Tel: 01895 250230  
Case Officer: Ed Laughton  
Email: [elaughton@hillingdon.gov.uk](mailto:elaughton@hillingdon.gov.uk)  
Date: 6th January 2022  
Our Ref: 924/PRC/2021/187

**RE: Extensions to care home facility**  
**SITE: Denville Hall Ducks Hill Road Northwood**

Project:
DENVILLE HALL - BUILDING A
NORTHWOOD - HA6 2SB

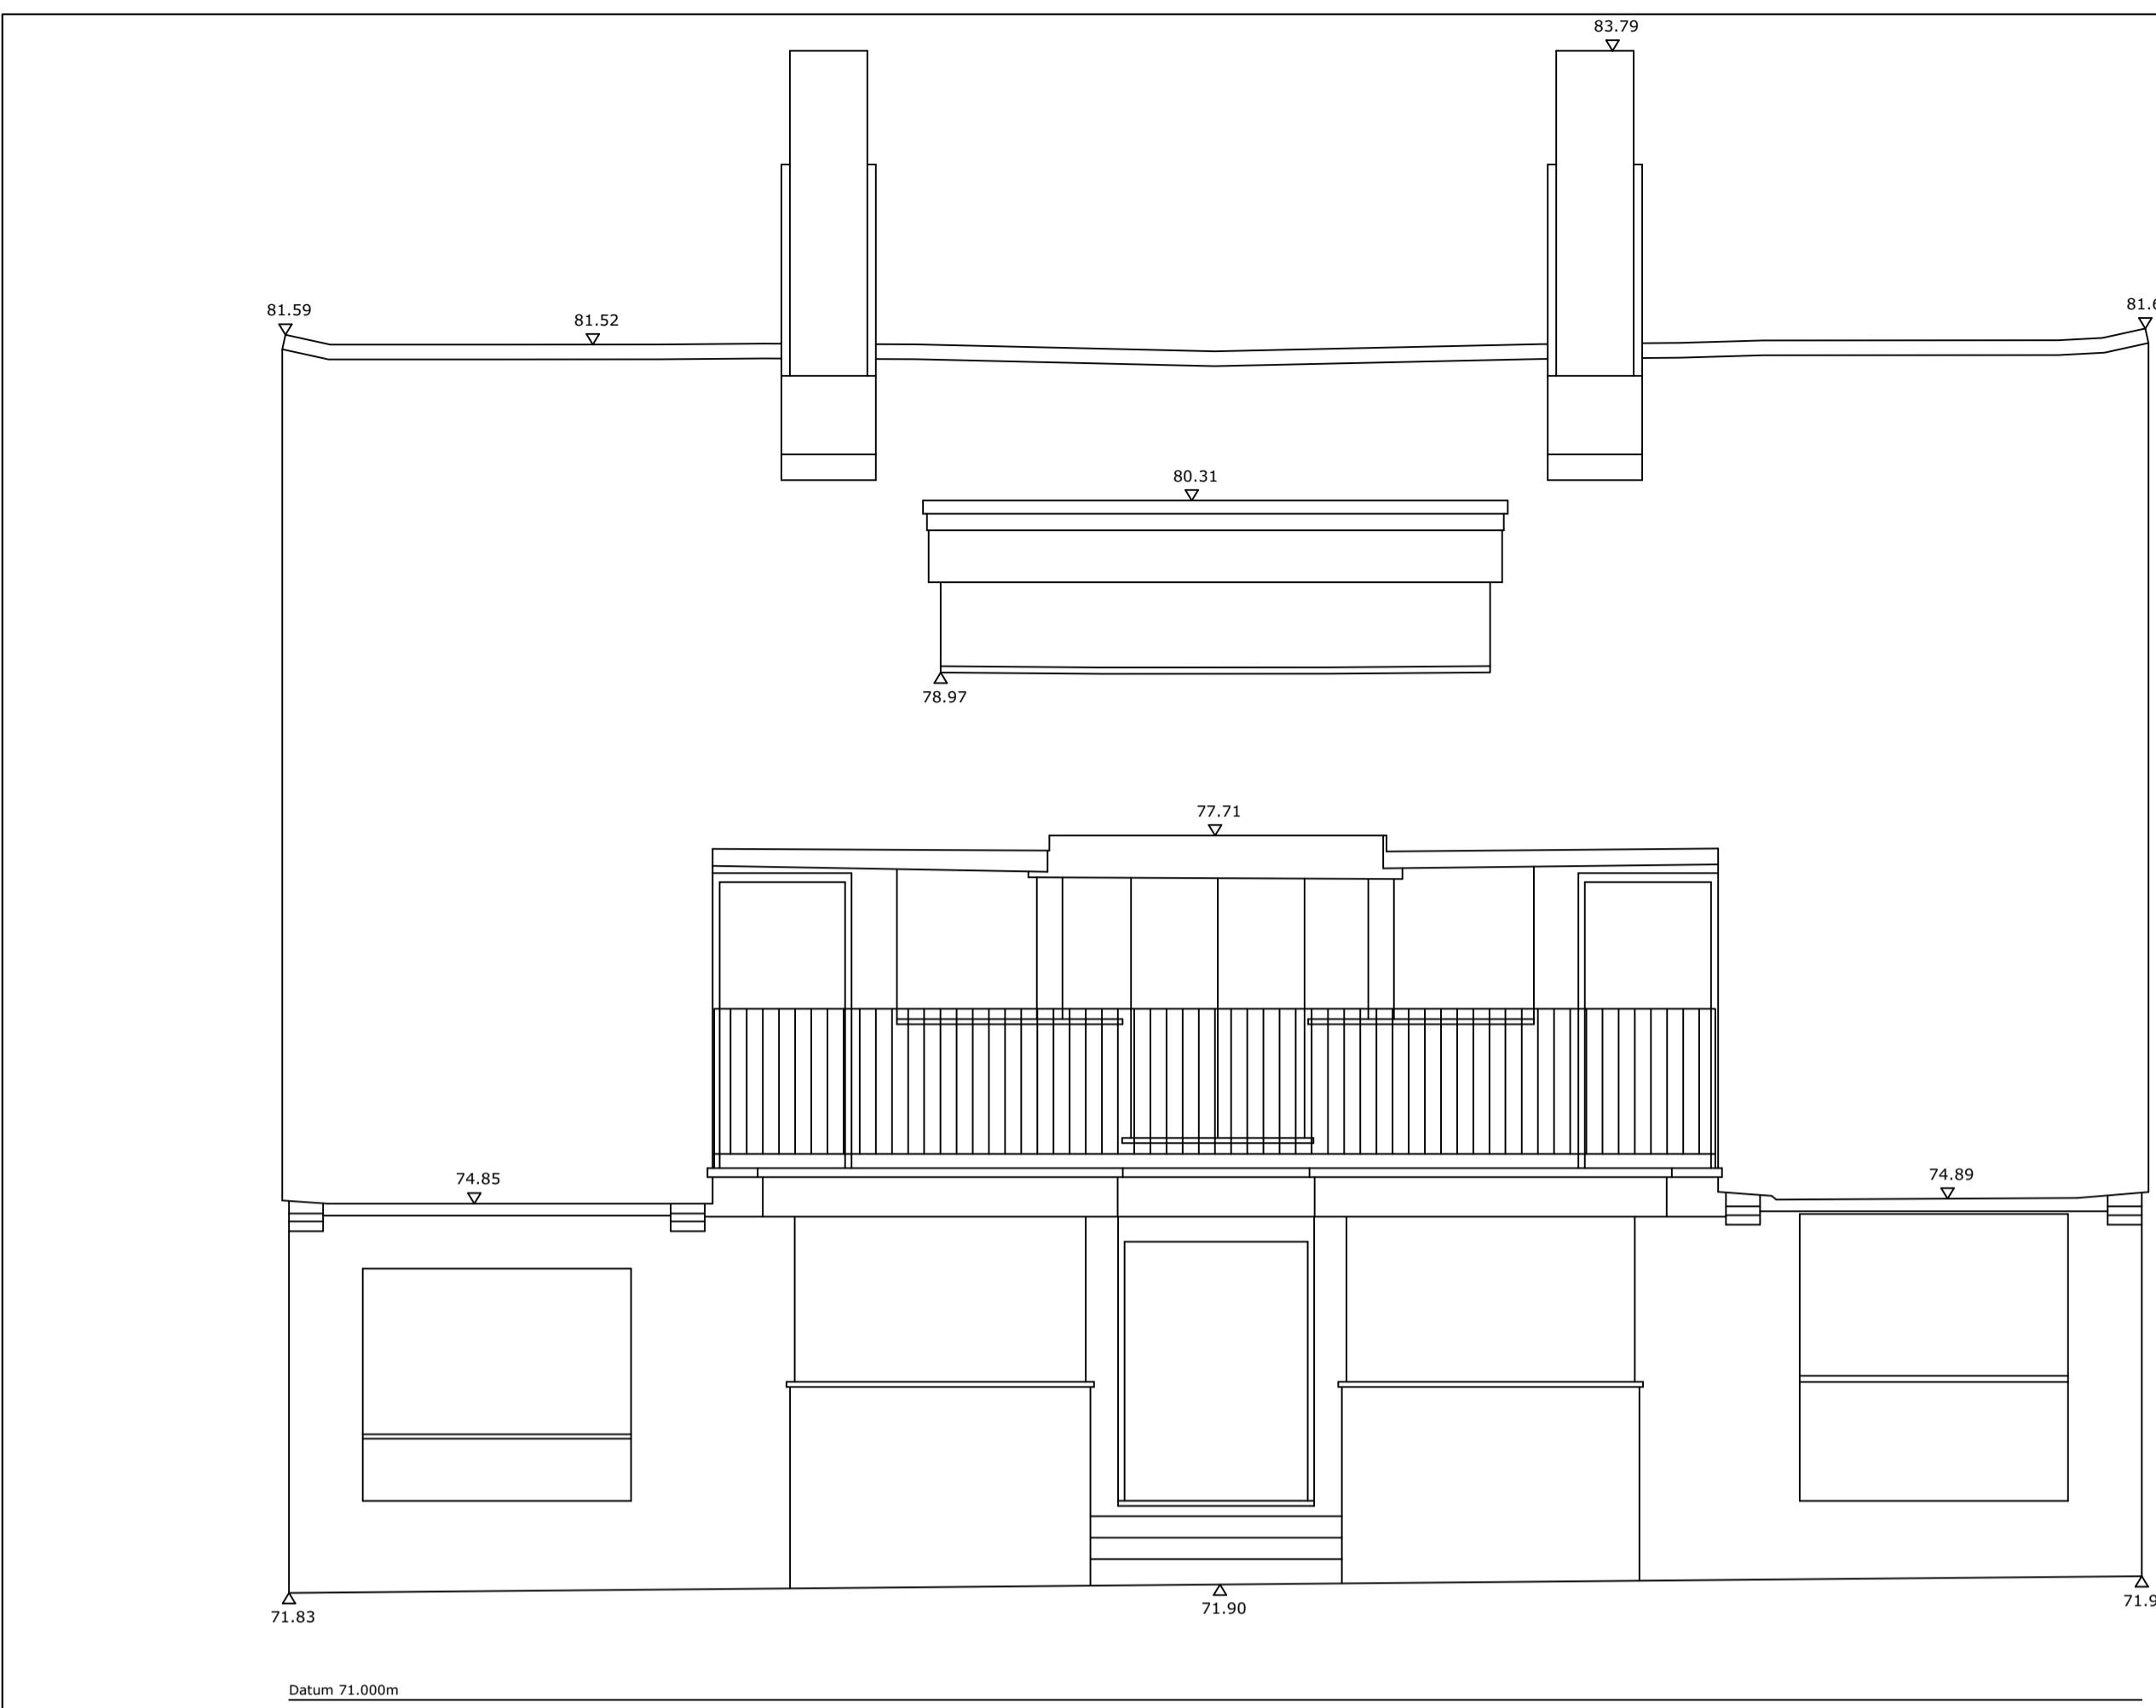
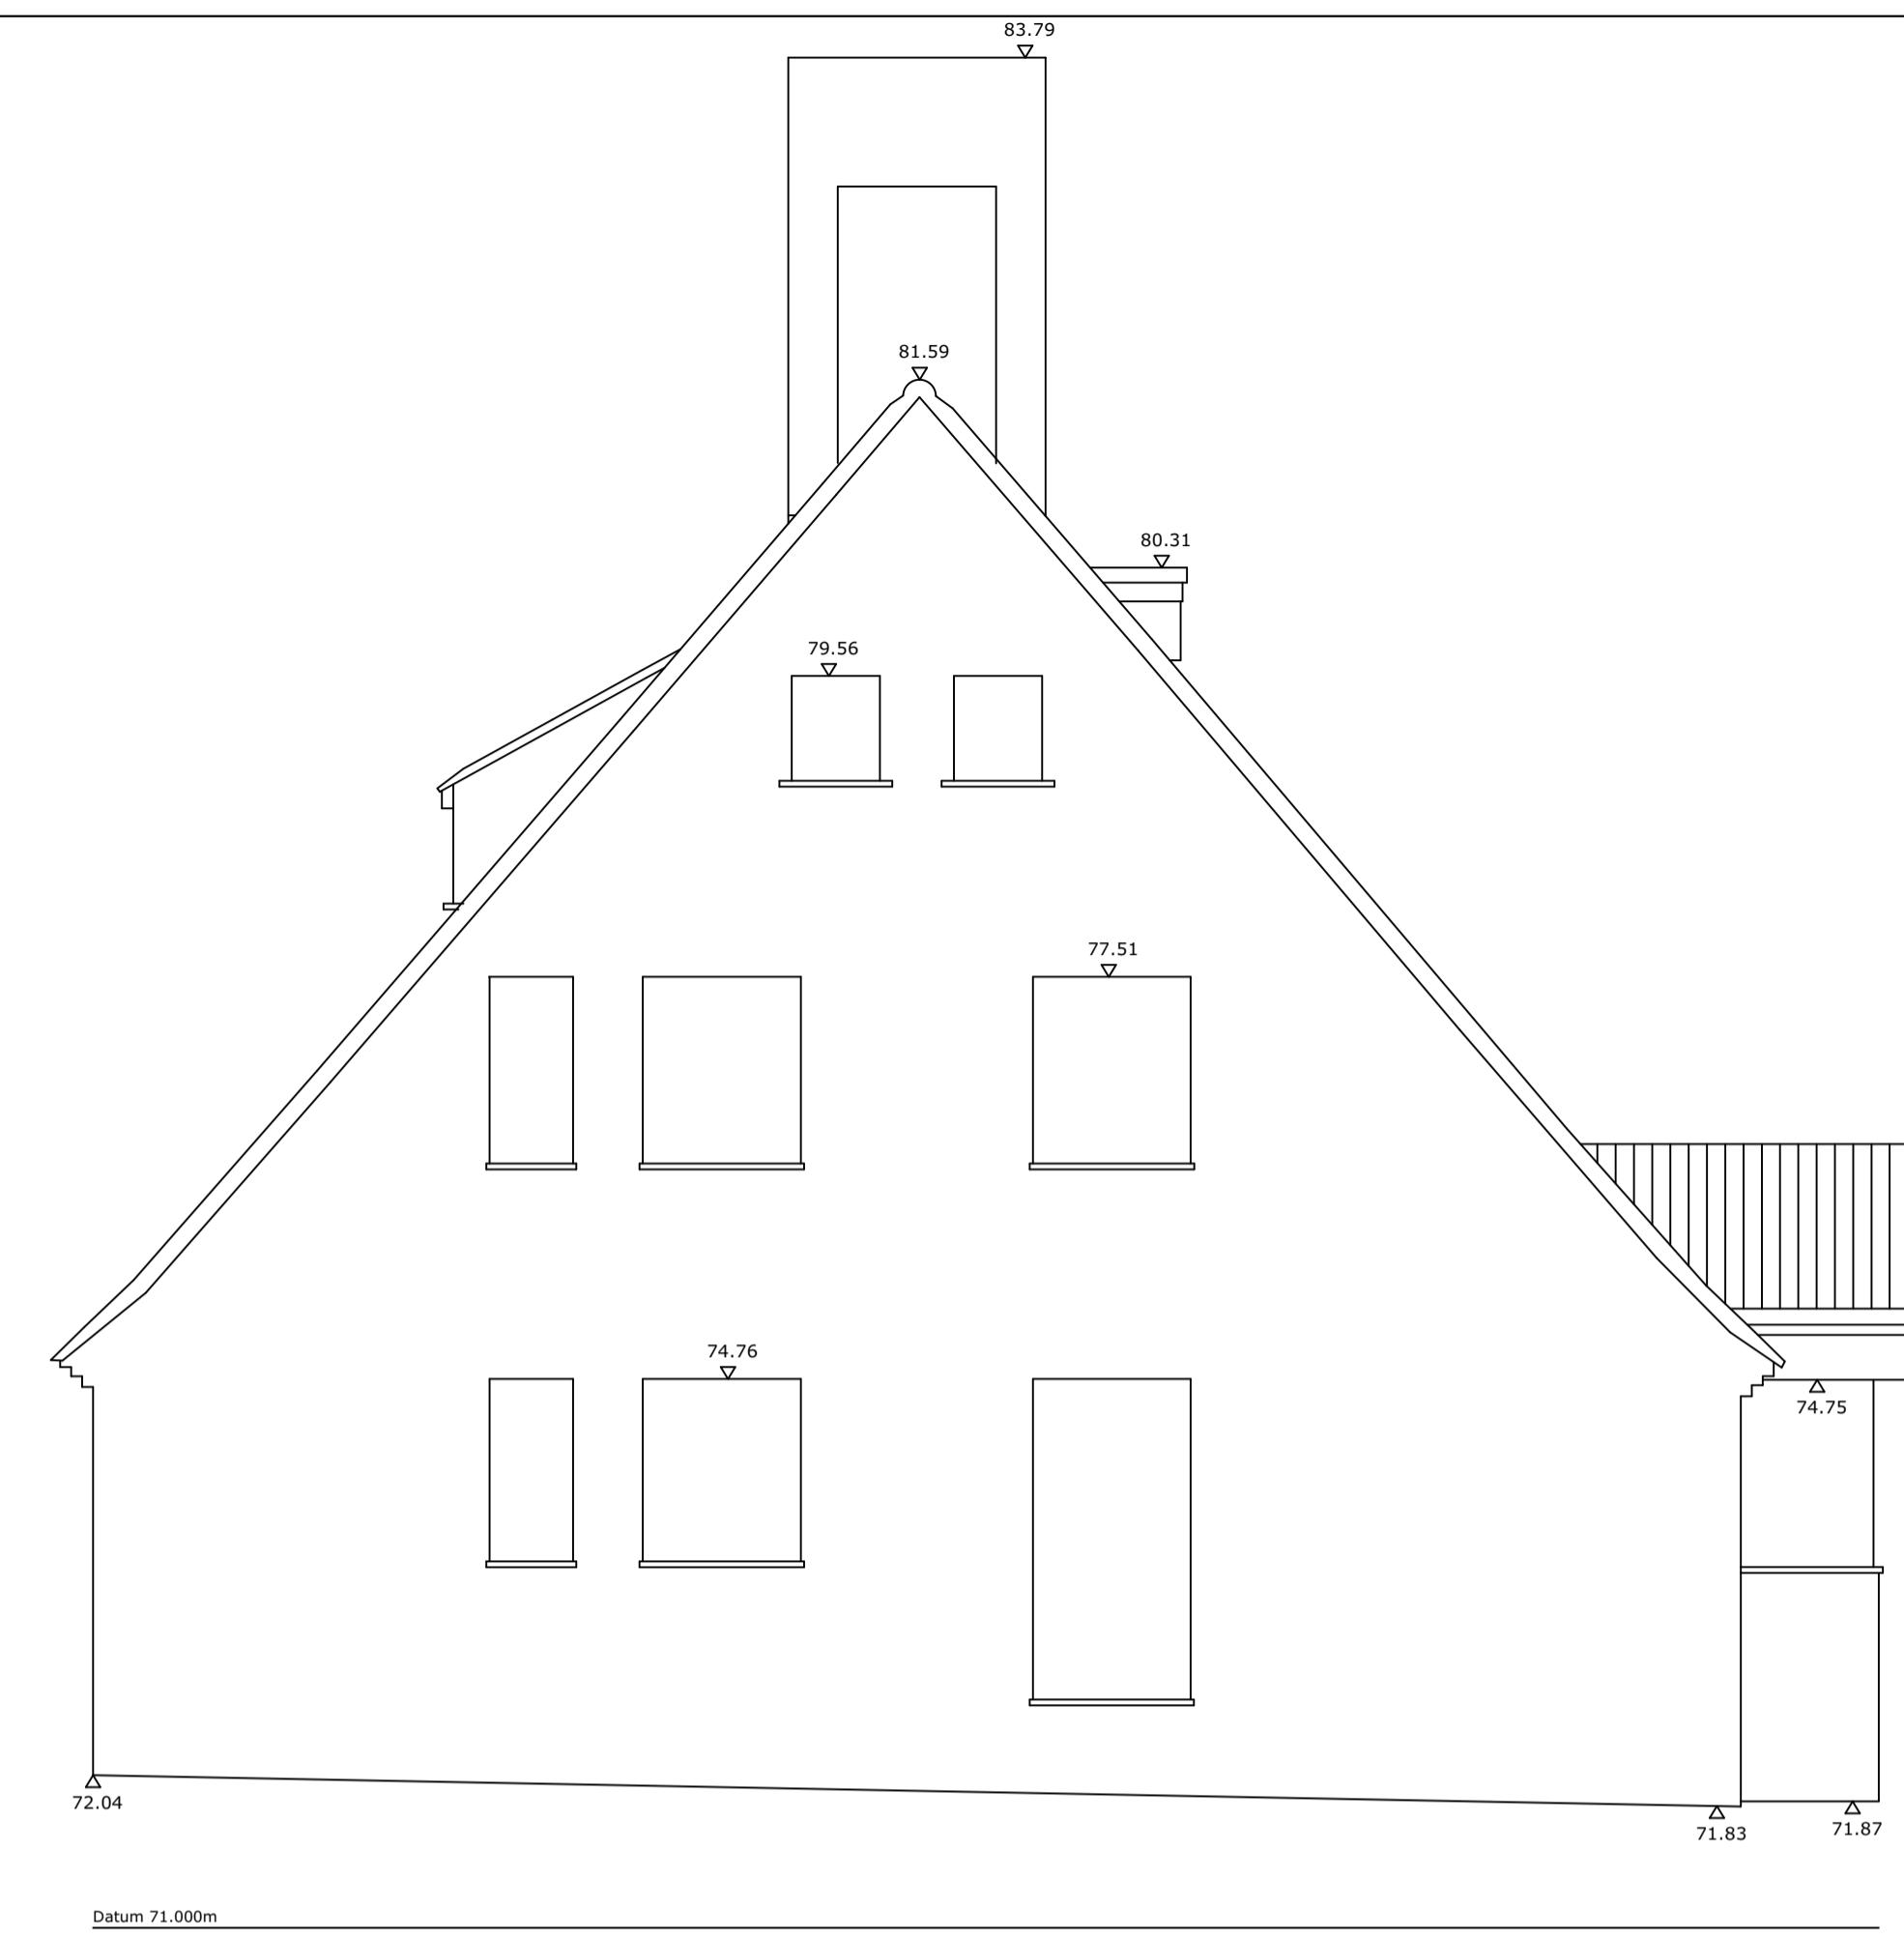
The proposed Building A would result in a larger and bulkier built form, directly adjacent to the existing Listed Building. The building would have a greater presence, particularly due to the increased height and no longer sit quietly within the setting of the Listed Building, exacerbating the harm already caused.

As proposed, Building A would be considered unacceptable and fails to preserve the setting of the Listed Building.
